SCOPING OPINION:

Proposed South East Strategic Reservoir Option (SESRO)

Case Reference: WA010005

08 October 2024

Figure 8.1 Designated sites

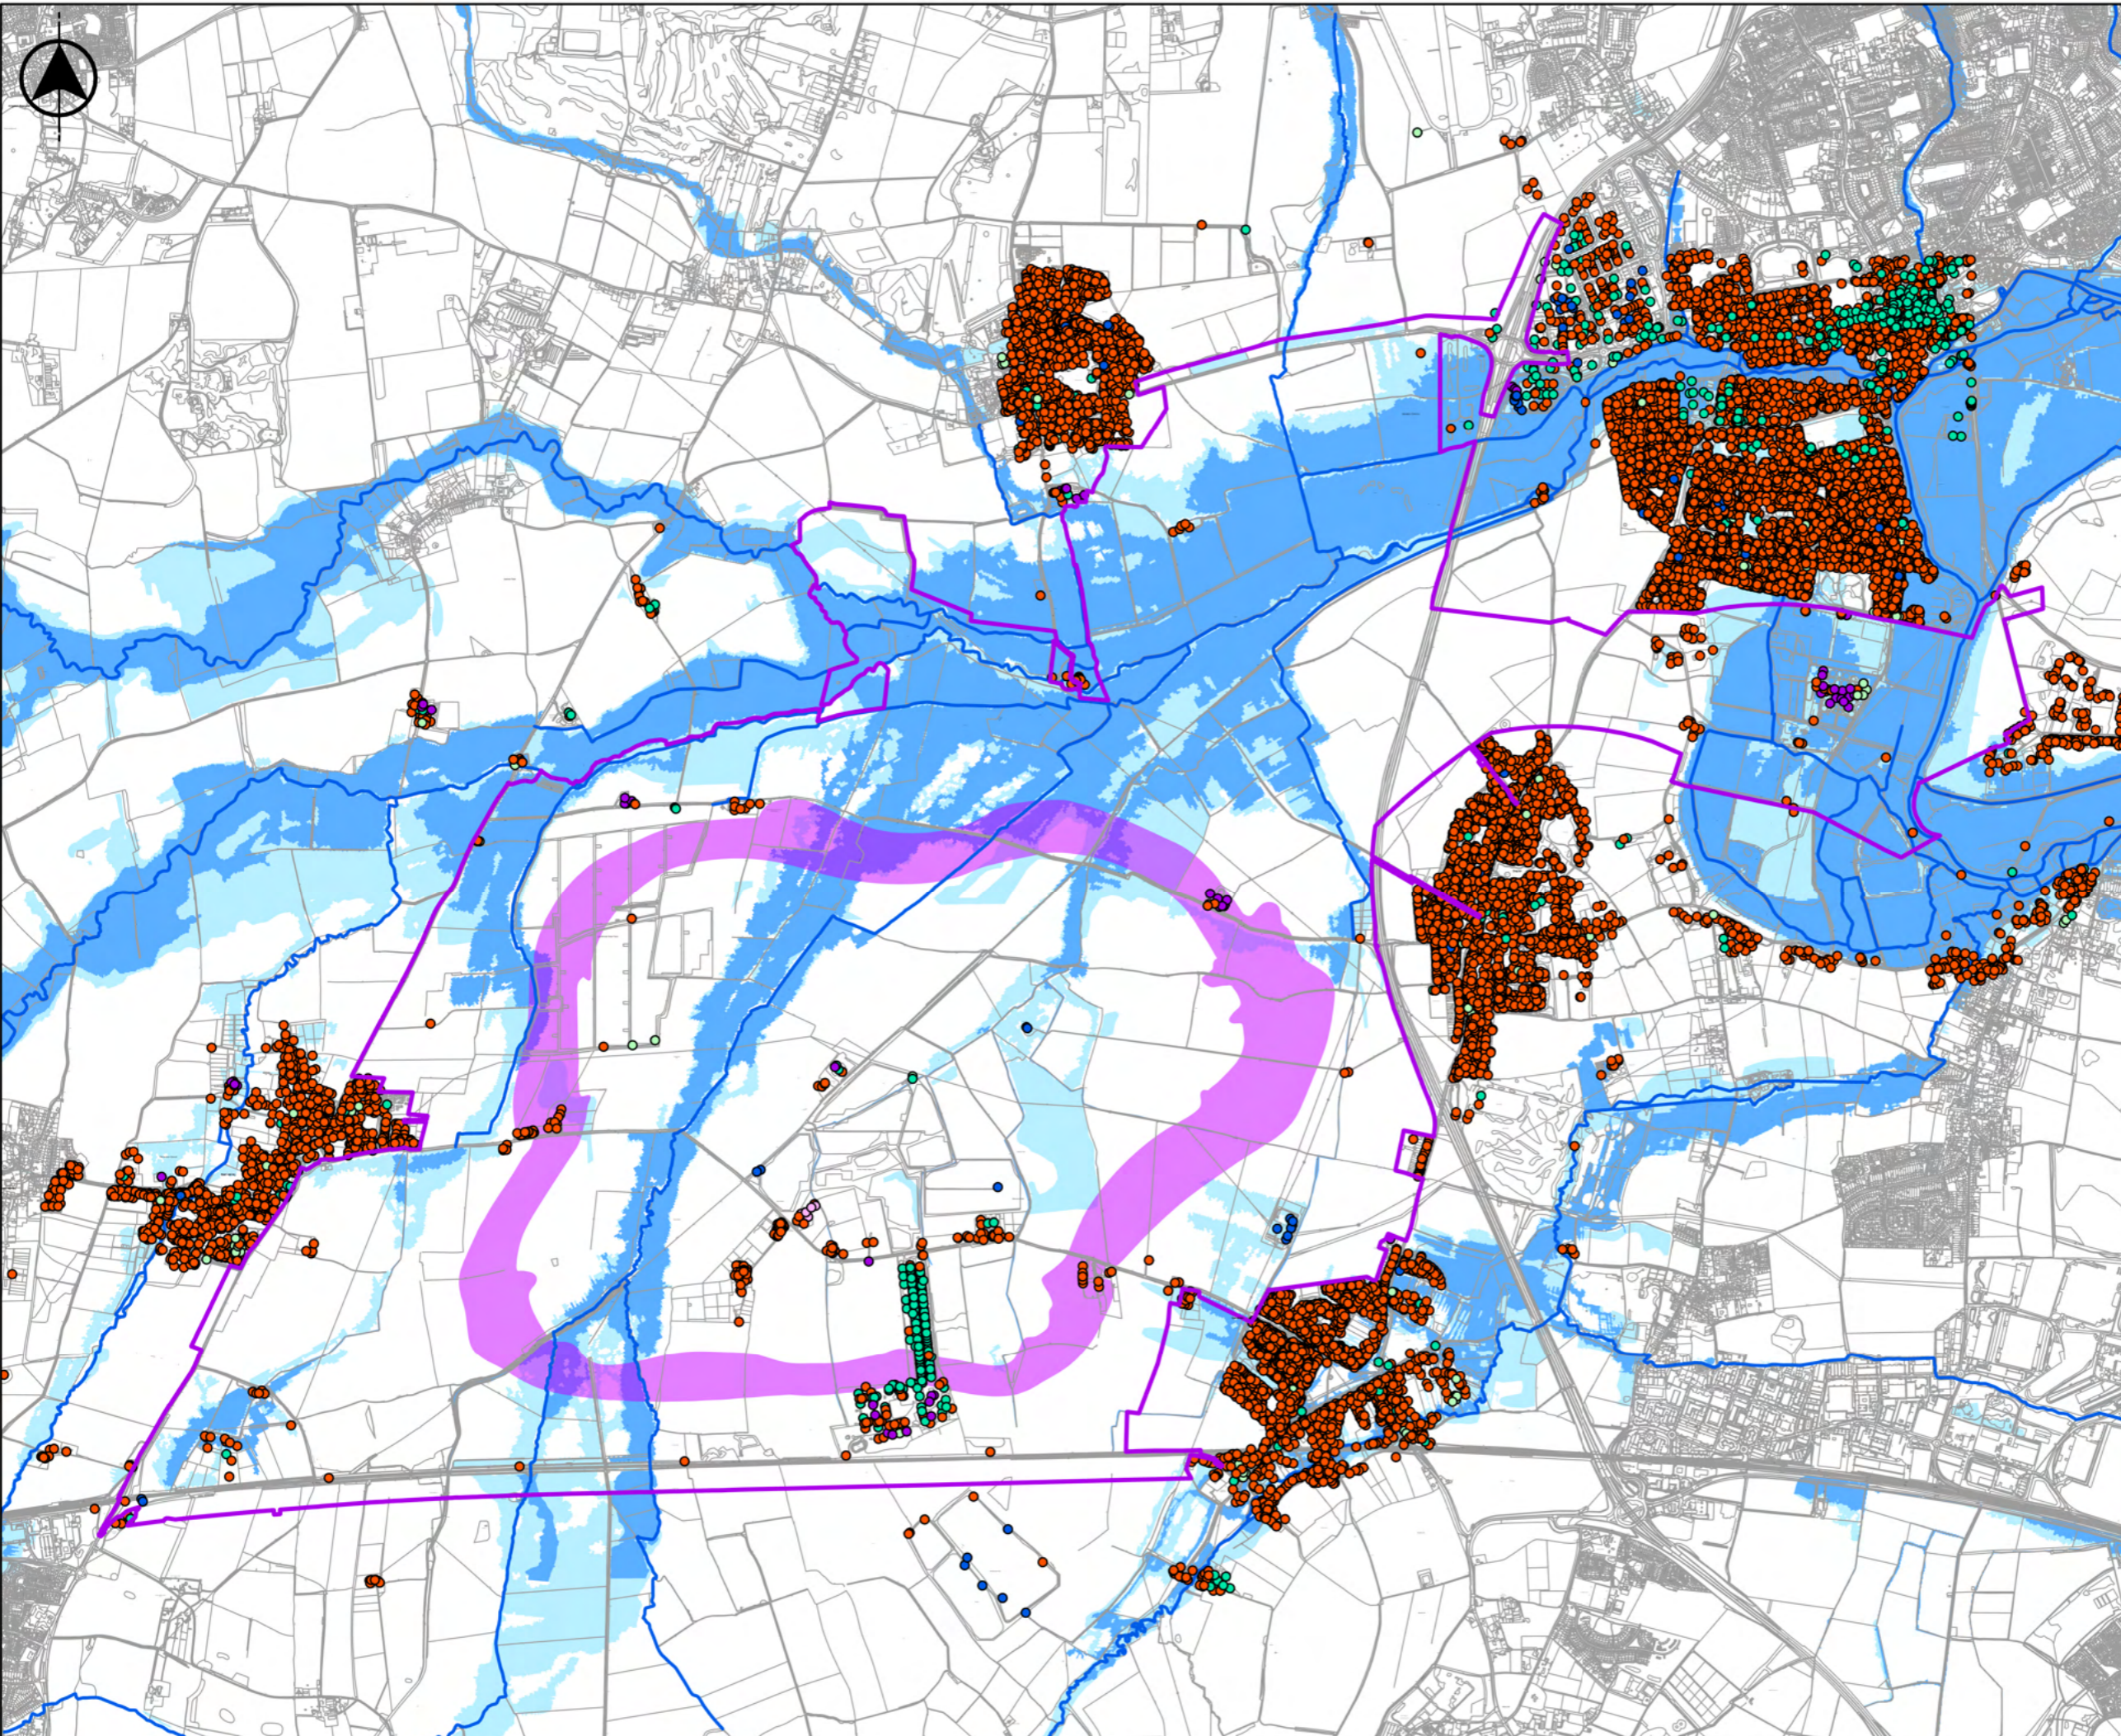
ID	Ref	Description	Inspectorate's comments
324	Table 7-3 and Figure 8.1	Location of Local Wildlife Sites (LWS)	<p>Scoping Report Table 7-3 identifies a number of designated LWS as hydrologically connected to the River Thames and the Proposed Development, however, they are not located on Scoping Report Figure 8.1 or any other figure.</p> <p>The ES should identify all designated site receptors that are hydrologically connected to the Proposed Development on a figure and this should correlate with any discussion within the ES chapters.</p>
325	Paragraph 7.6.11	Box culverts	<p>Box culverts are proposed to be considered for crossing small watercourses and ditches. However, the Environment Agency advise that this is not appropriate mitigation as longitudinal migration of aquatic species must be maintained (see Appendix 2). The ES should describe the mitigation measures for crossing small watercourses and ditches, explain why it is appropriate and how it maintains longitudinal migration of relevant species.</p>

Figure 8.2 Important habitats

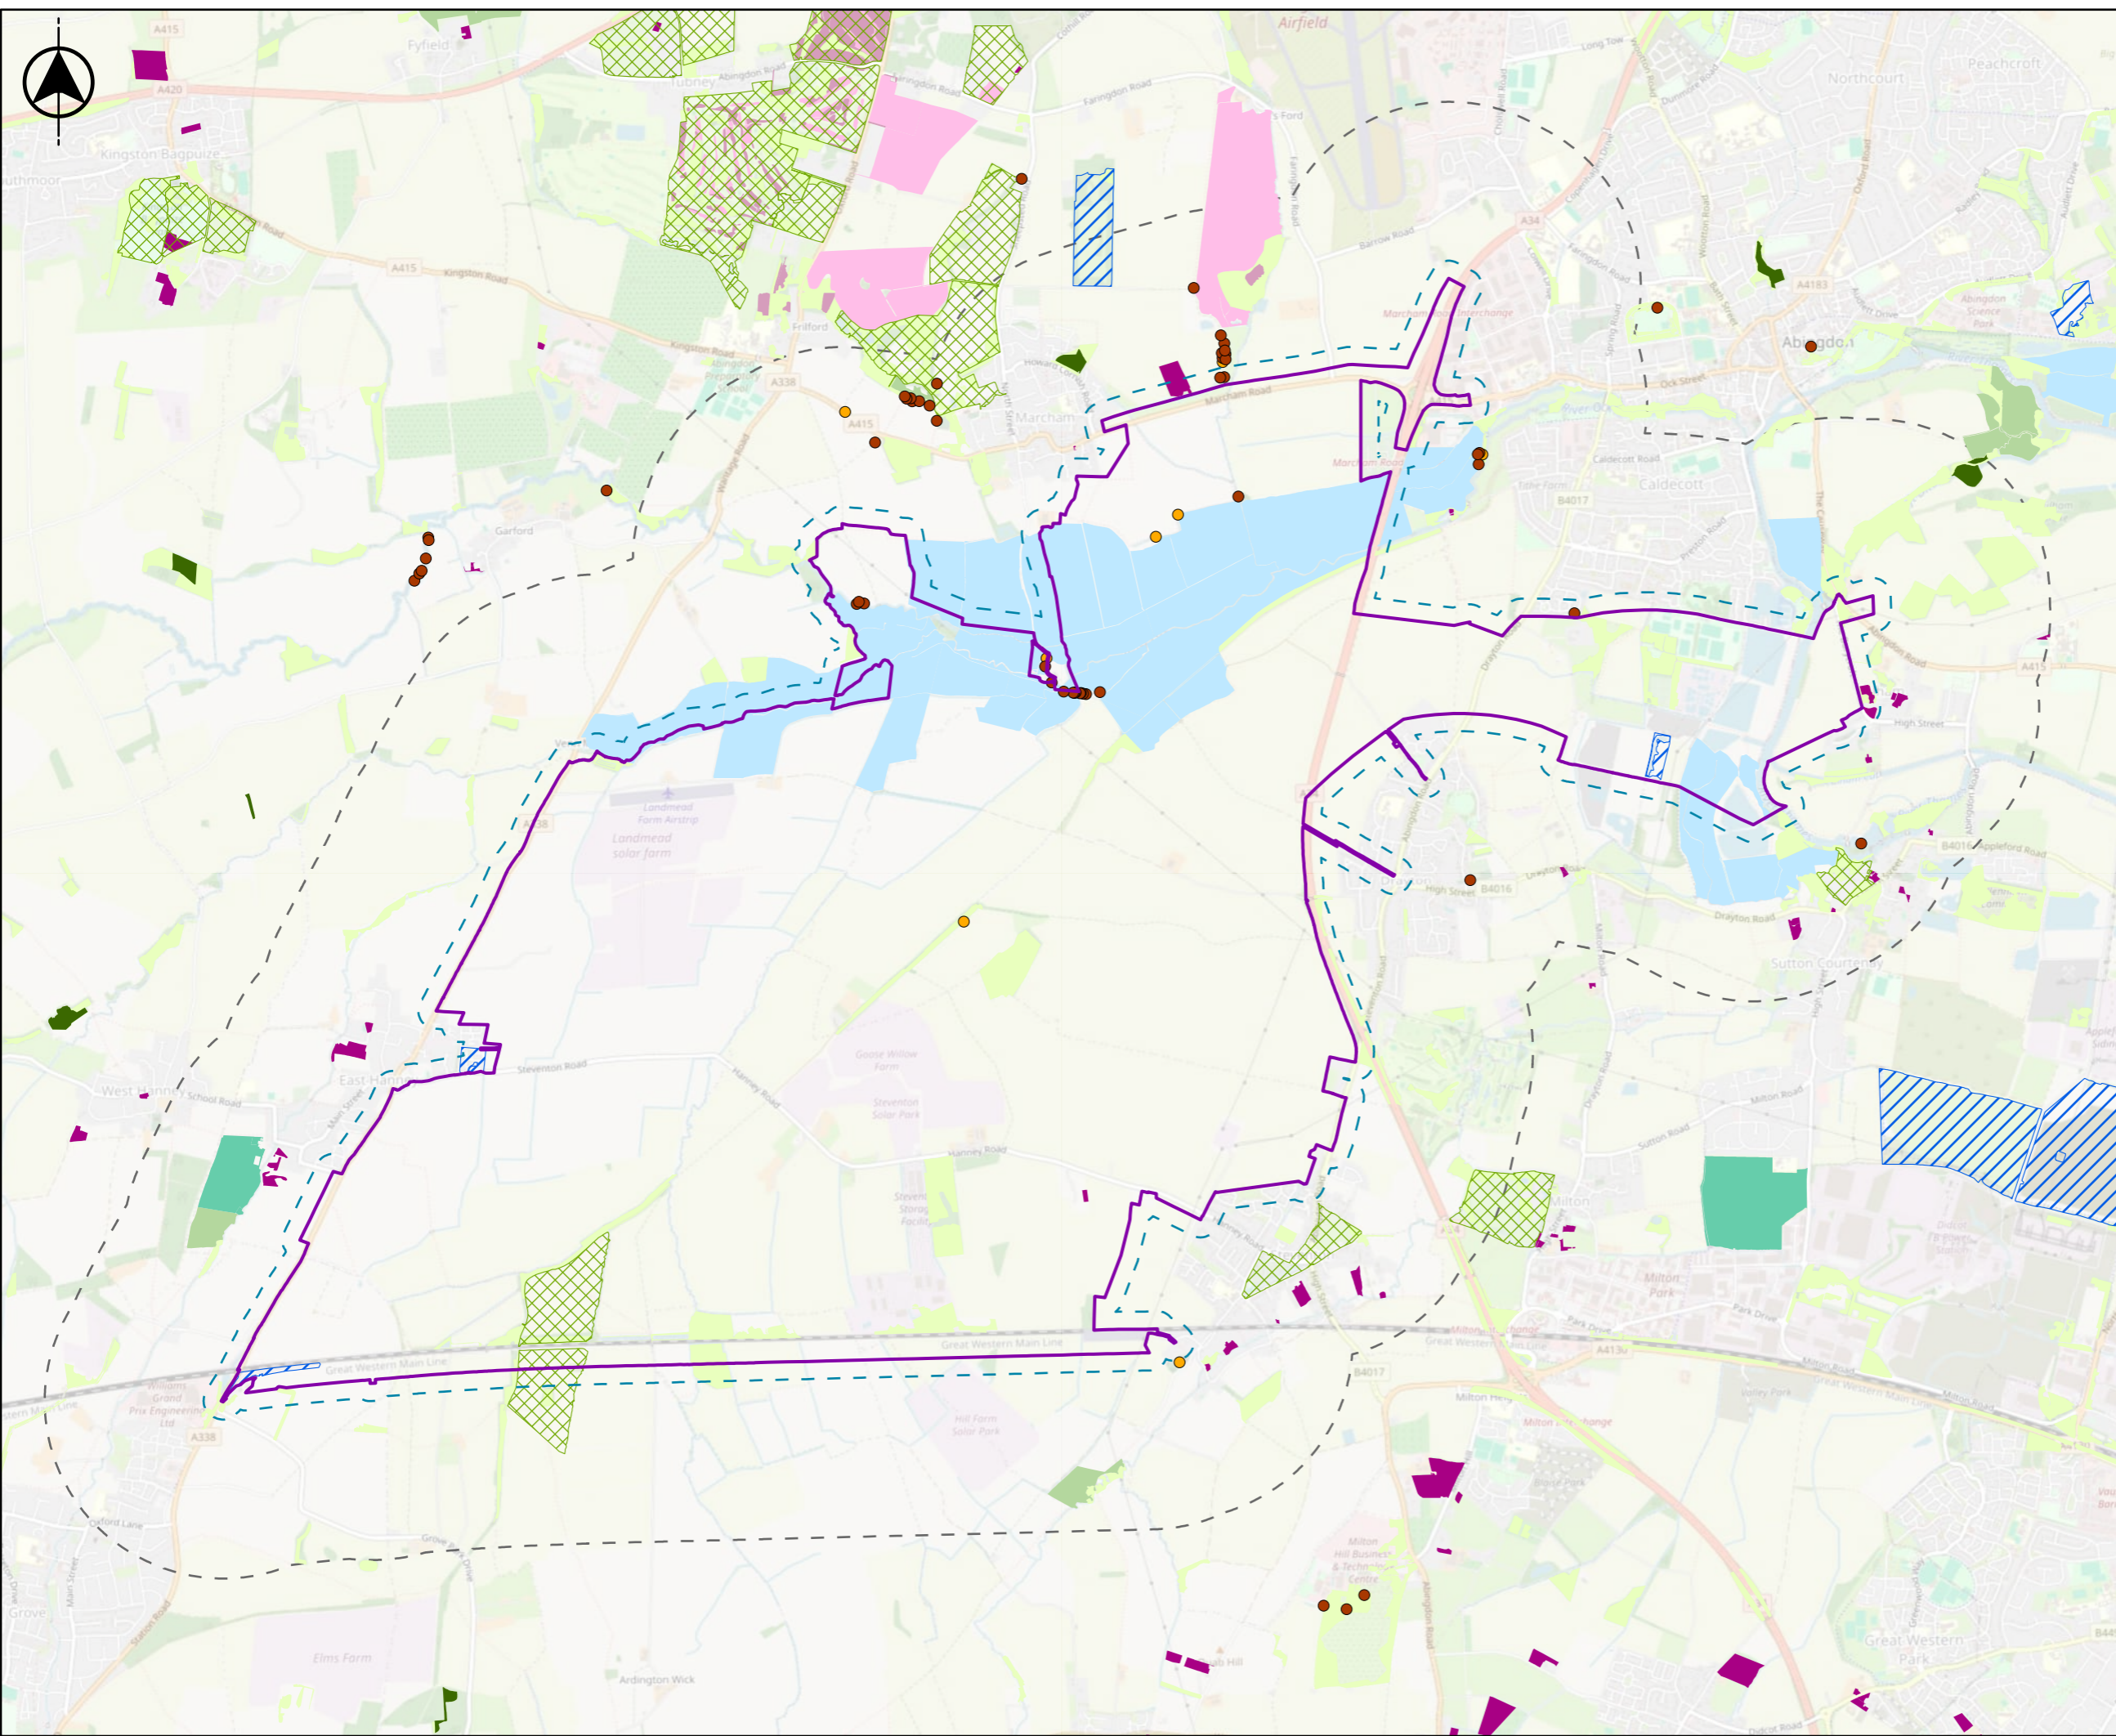
33.12	Paragraph 8.8.62-8.8.64 and Figure 8.2.	Ancient/veteran trees - operation	<p>The Scoping Report explains that there are some ancient and veteran trees identified within the Proposed Development site boundary, the location of these trees is shown in Figure 8.2. the Scoping Report states that one ancient tree would be removed as a result of the Proposed Development and further survey work is ongoing to establish if there are other ancient/veteran trees which may be affected.</p> <p>As survey work is still ongoing to establish the presence of ancient/veteran trees, the Inspectorate does not agree to scope this matter out. Effects on ancient and veteran trees should be addressed in the ES, where there is potential for likely significant effects to occur.</p>
